Letter of Intent for Site Development Plan

RE: File No. PPR2443 (Site Development Plan - Monument Glamping I)

UPDATE: Review comments from EPC Stormwater Review

SITE PLAN

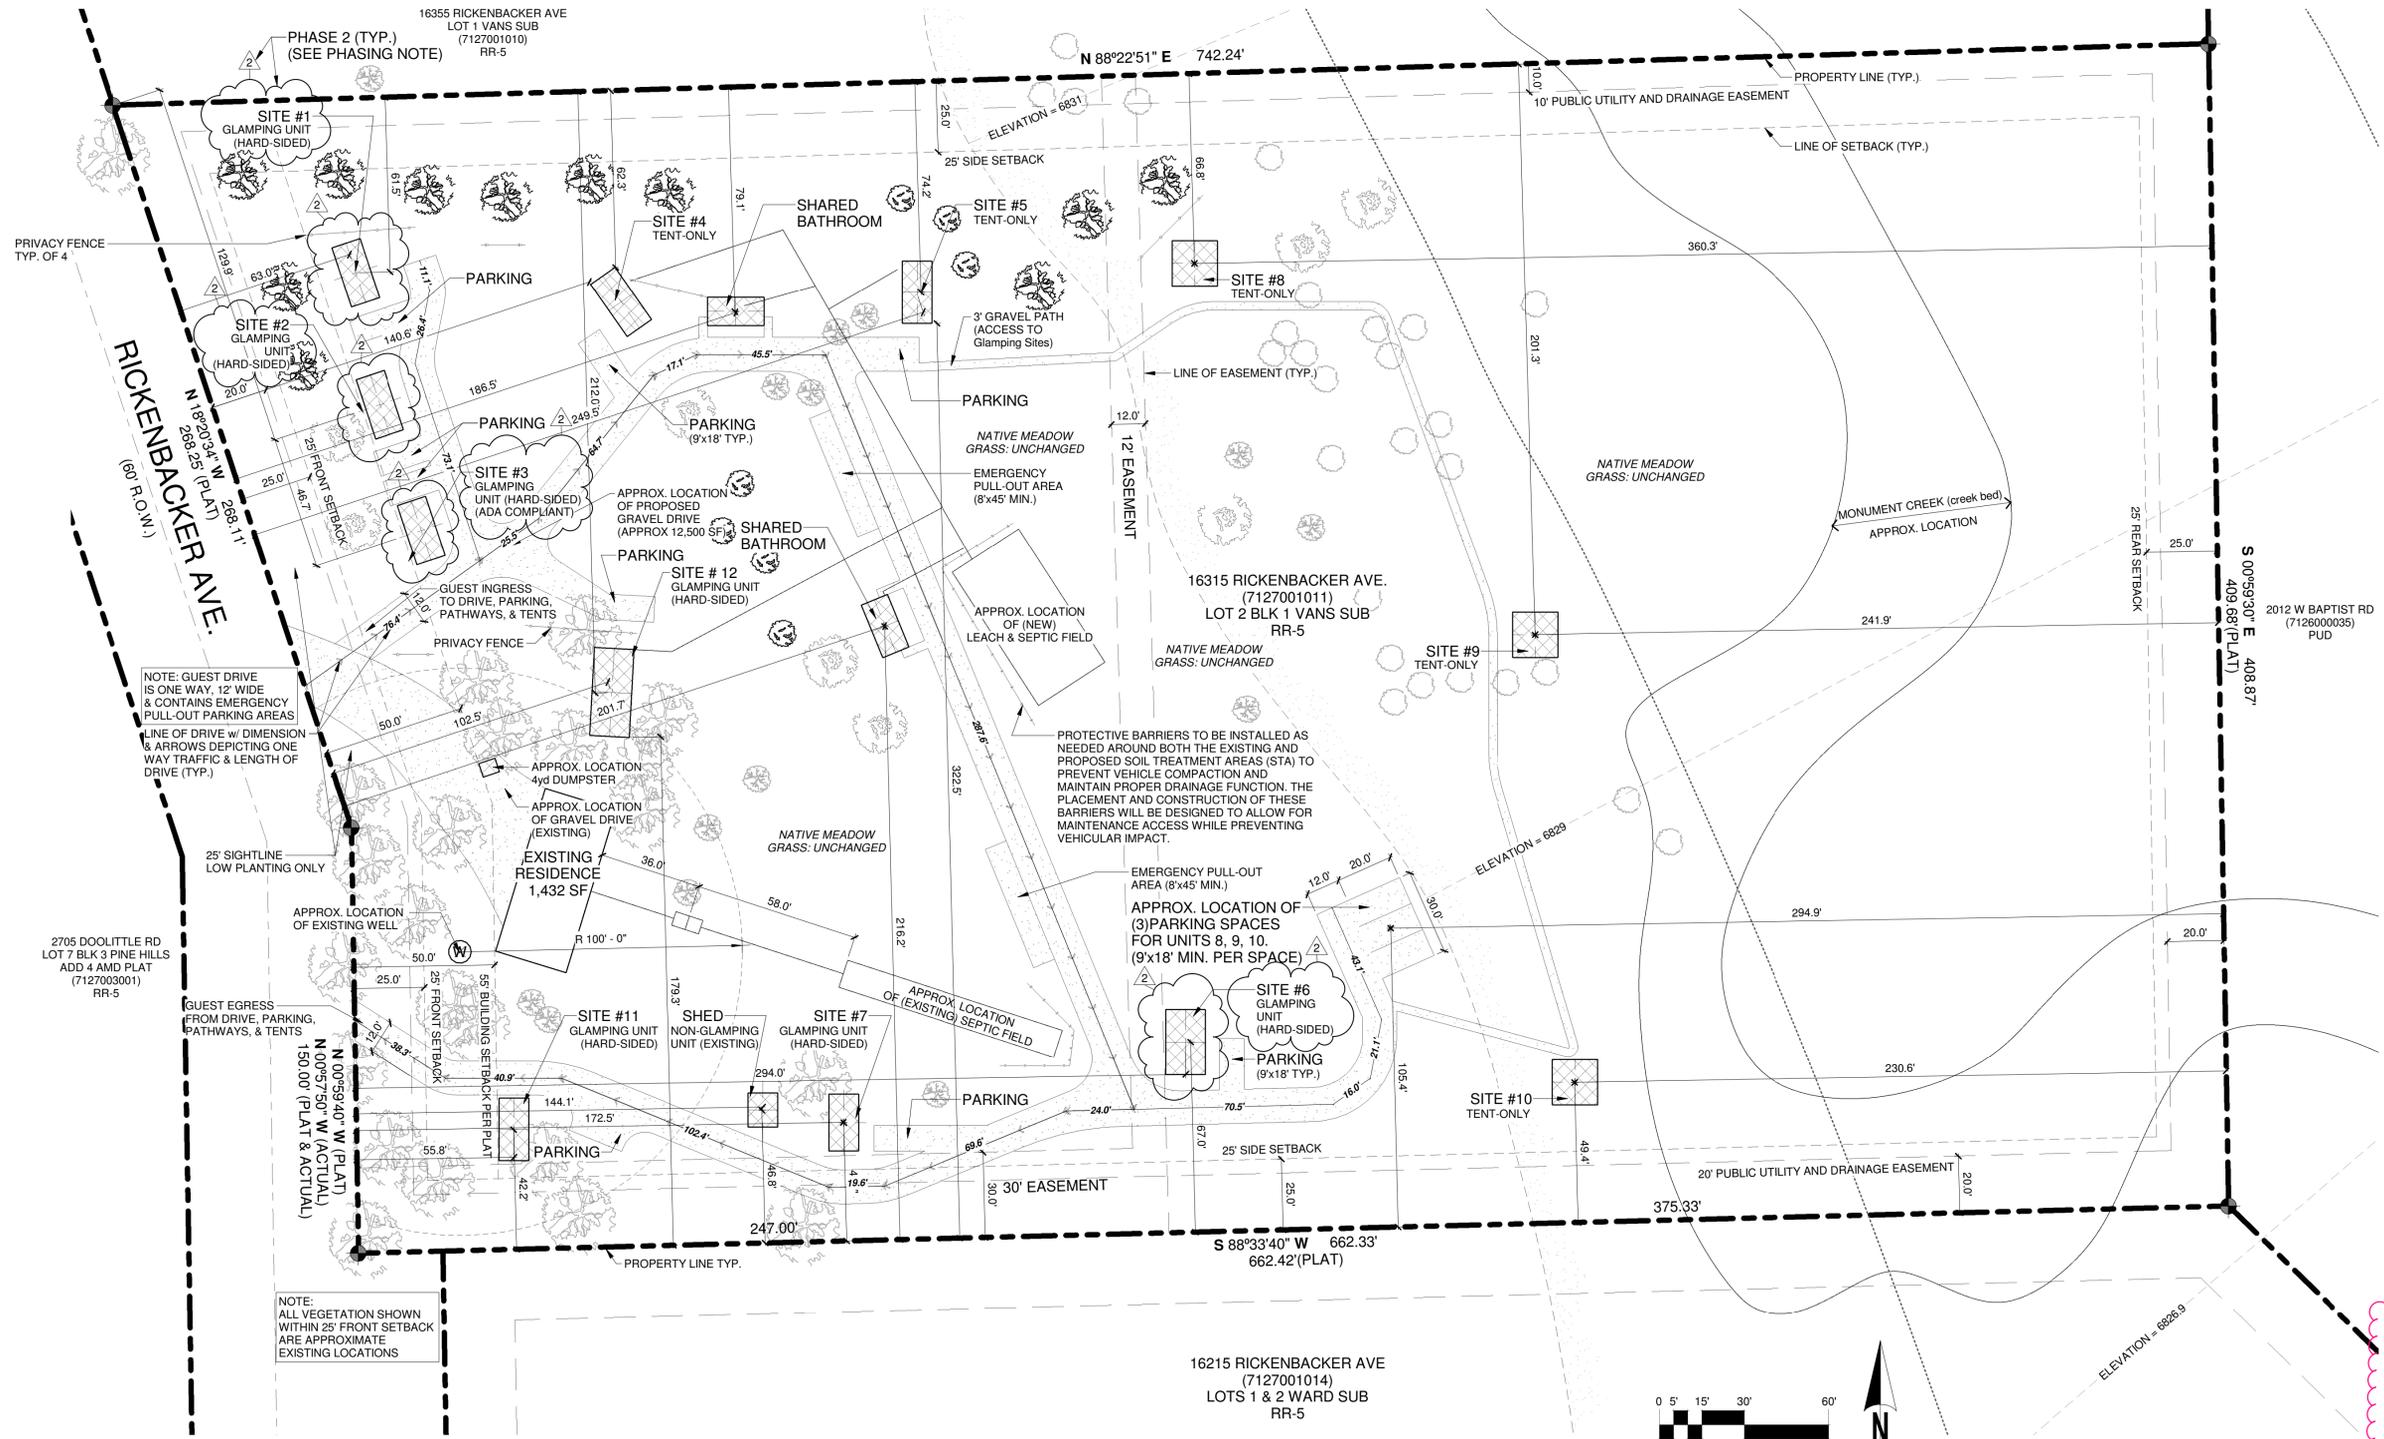
- **Show & label all existing structures. I counted 8 existing structures on aerial imagery that are not show on this map.** —A new map titled “Existing Conditions” lays out the existing MG1 as of January 18, 2025. We hope this serves as a base understanding for Stormwater.
- **Additionally there are roadway disturbances seen on aerials on the eastern half of the parcel that are not shown on this map.** —The original map was not closely surveyed, but these maps included an overlay of an aerial map (by All Terrain Engineering) of the property. All roadway disturbances are now accurately mapped on all three of the maps.
- **For both cases (existing structures and roads), if they are to be demo'd and returned to pre-existing conditions and re-vegetated, then make such a note on this map to document that.** —The additional maps “Phase 1” and “Phase 2” show how we plan to develop.
